Application no: H16-0011-11

Description: Two new external doors and refurbish existing windows and replacement signage

Location: 2 Pinchbeck Road
Spalding
Lincs
PE11 1QD

Amendment: Revision showing new signage to be sign written upon
20mm Marine Ply (dwg. no. 1043-01-A)

Scale 1:50 1:20 1:10 1:25	Drawing No. 1043-01-A
Date. JAN. 11	Drawn. J.C.

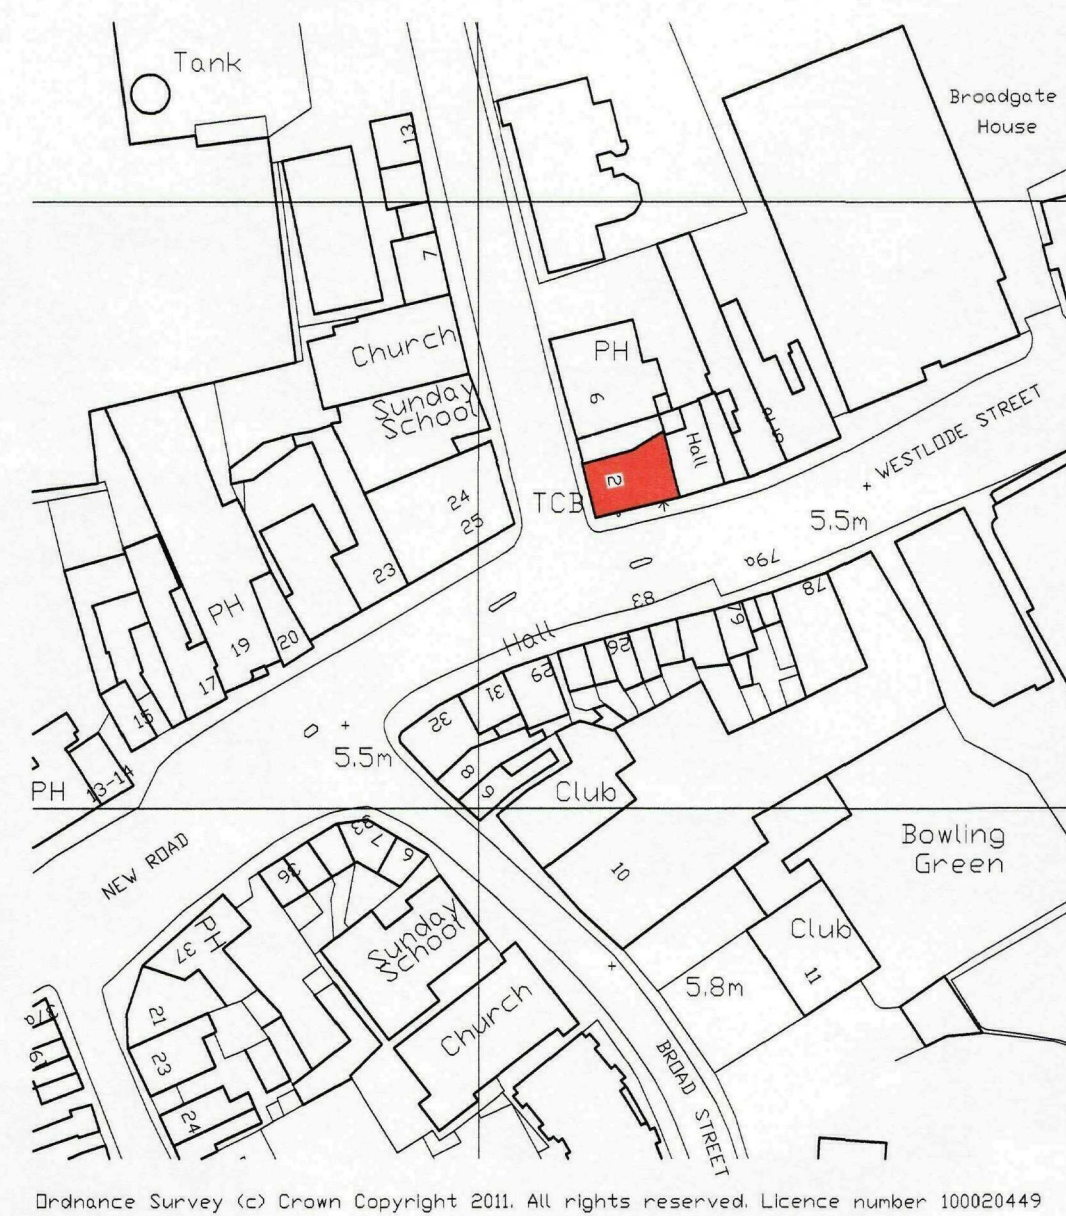
Please find enclosed revised plans which now show that all of the new signage will be sign
written upon painted 20mm Marine Ply in lieu of Perspex.

We would also confirm that the signs will not be illuminated, other than the spot lights to the
Hanging Sign and the existing illuminated Menu Box.
